**KIRKLEES METROPOLITAN COUNCIL
INVESTMENT & REGENERATION SERVICE**

**DELEGATED DECISION TO DETERMINE APPLICATIONS FOR
CONSENT, AGREEMENT OR APPROVAL REQUIRED BY CONDITION**

Reference No:	2025/44/92961/W
Site Address:	Crown House, 12, Southgate, Huddersfield, HD1 1DE
Description:	Discharge of details reserved by conditions 3 (C(E)MP), 4 (CEMP: Biodiversity), 5 (Air Quality Impact Assessment), 6 (Noise Impact Assessment), 7 (external facing materials), 8 (bin store), 9 (external facing materials), 10 (BEMP), 11 (invasive species protocol), 14 (noise management plan) on previous permission 2022/93932 for change of use of crown house to provide student-only living accommodation (sui generis) in the form of studios (198), with ancillary concierge and communal facilities including an open plan lounge, coffee bar and gym at ground floor, with laundry, car parking, cycle store, parcel store and plant rooms at basement level and associated works including the installation of new cladding and fenestration to the elevations with a new roof garden atop the building
Recommending Officer:	Ellie Thornhill

Application: 2025/92961

Podium Detail - Section

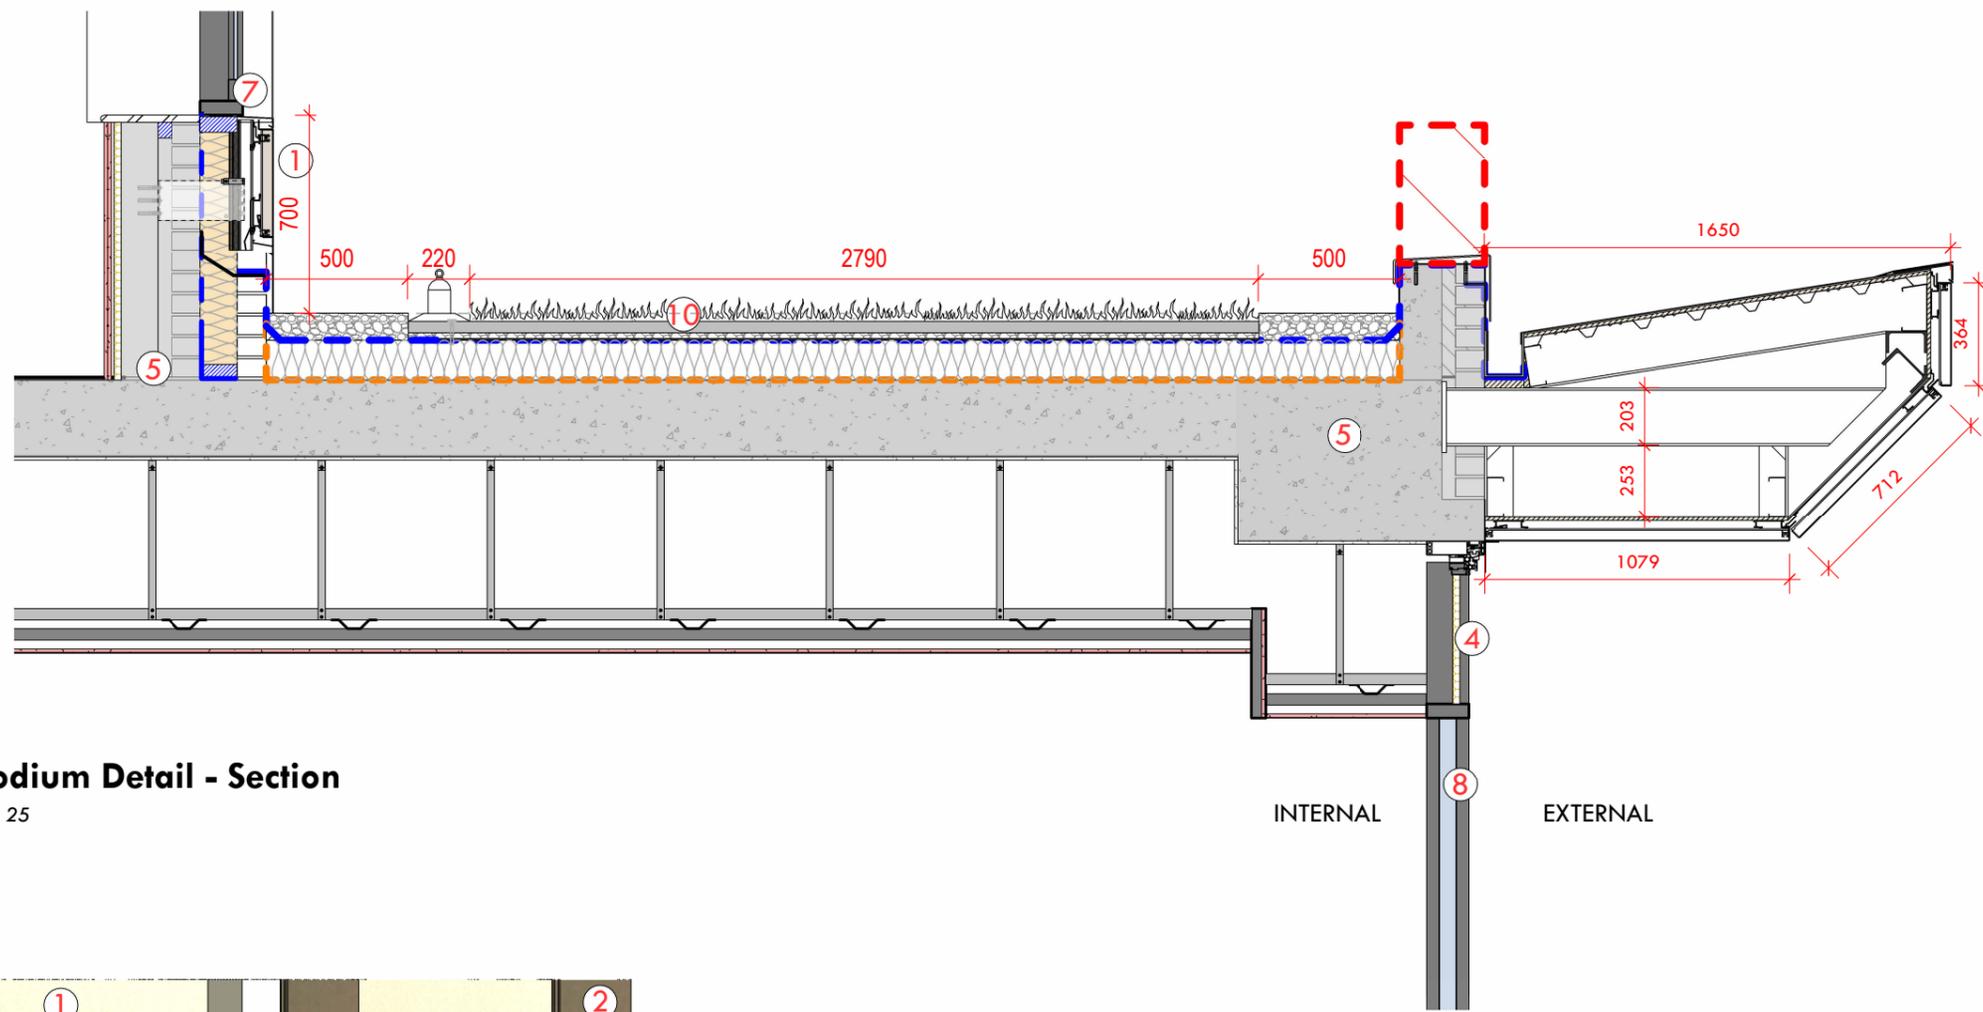
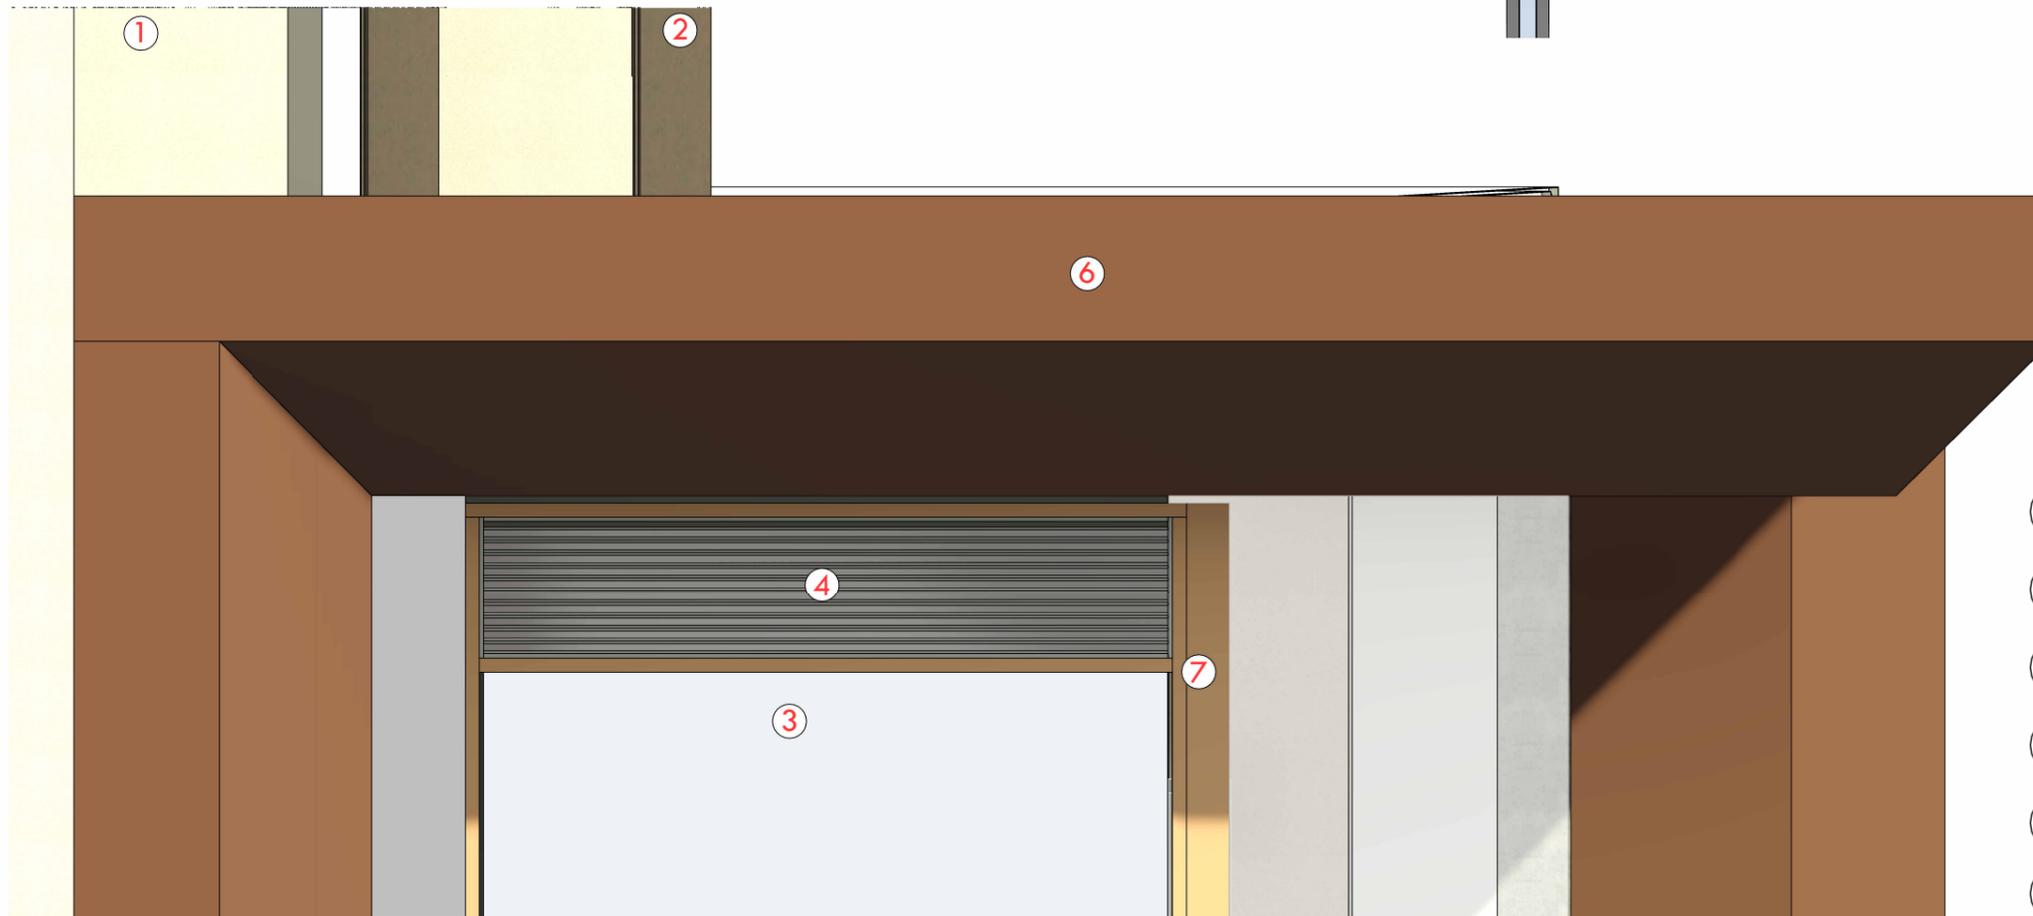
- *04 – What material and colour is proposed for the insulated louvered panels? Drawings P-7001 rev P01 and P-7000 rev P01 appear to show different colours.*

- 10 – If approval of details of the green roof to the podium is being sought, more details of the proposed green roof system (including type, substrate depths, irrigation, maintenance, species proposed etc) would be needed.
